# Rezoning Transportation Analysis

Petition Number: #2022-047

General Location Identifier: 09513114

Date	Description
08-22-2022	First Review (AO)

REV. A	Alezu Inc. GC License No. 78741
REV.	Joseph Leland
REV.	Rezoning Site Plan
REV.	2718 Eastway Dr.
REV.	R2P 2022-047

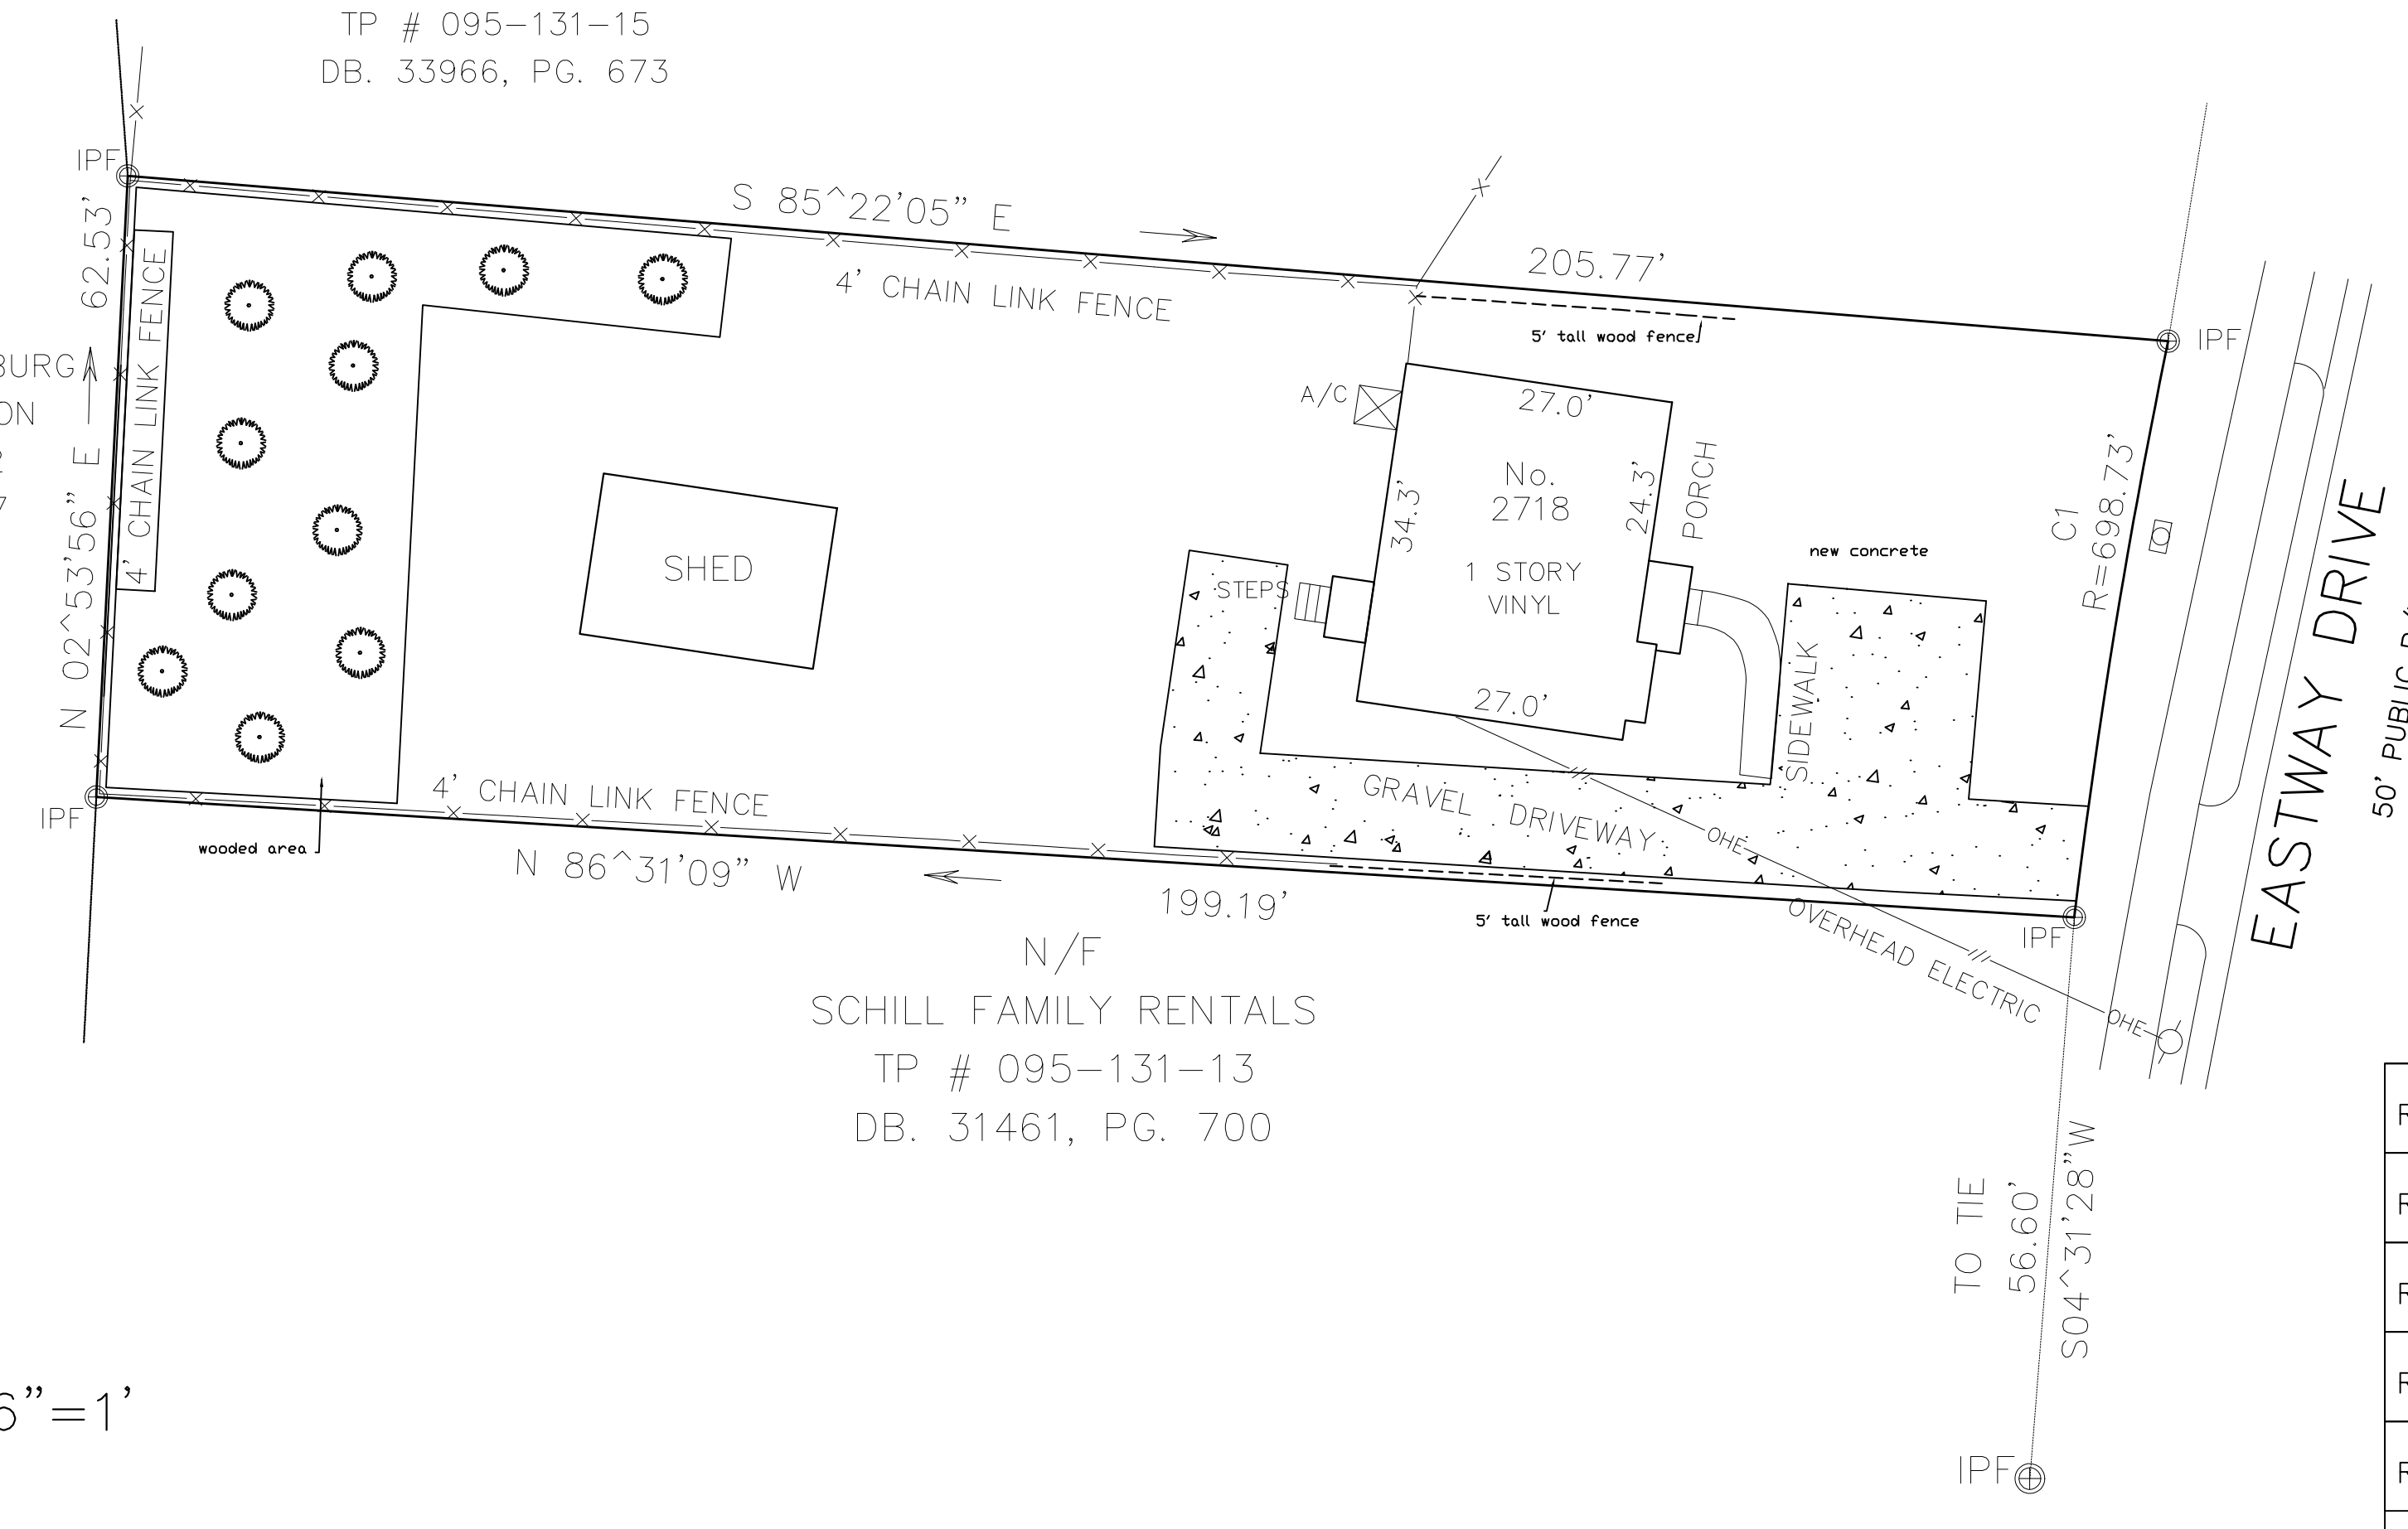
2. Revise site plan and conditional note(s) to commit to dedicate 40-feet of right-of-way from the road centerline of Eastway Dr. The site plan shall label and dimension the right-of-way from the road centerline.
3. Revise site plan and conditional note(s) to commit to replacing the existing driveway to tie-into proposed internal gravel driveway.

4. A site plan note(s) specifying dedication and fee simple conveyance of all rights-of-way to the City before the site's first building certificate of occupancy is issued as needed. CDOT requests rights-of-way set at 2' behind back of sidewalk where feasible.
5. A site plan note specifying that all transportation improvements will be approved and constructed before the site's first building certificate of occupancy is issued as needed. The petitioner may phase transportation improvements if said improvements and phasing are explicitly described in site plan notes.

6. Add conditional note "All public roadway improvements will be subject to the standards and criteria of CDOT and NCDOT, as applicable, to the roadway improvements within their respective road system authority. It is understood that such improvements may be undertaken by the Petitioner on its own or in conjunction with other development or roadway projects taking place within the broad north eastern Mecklenburg area, by way of a private/public partnership effort or other public sector project support."
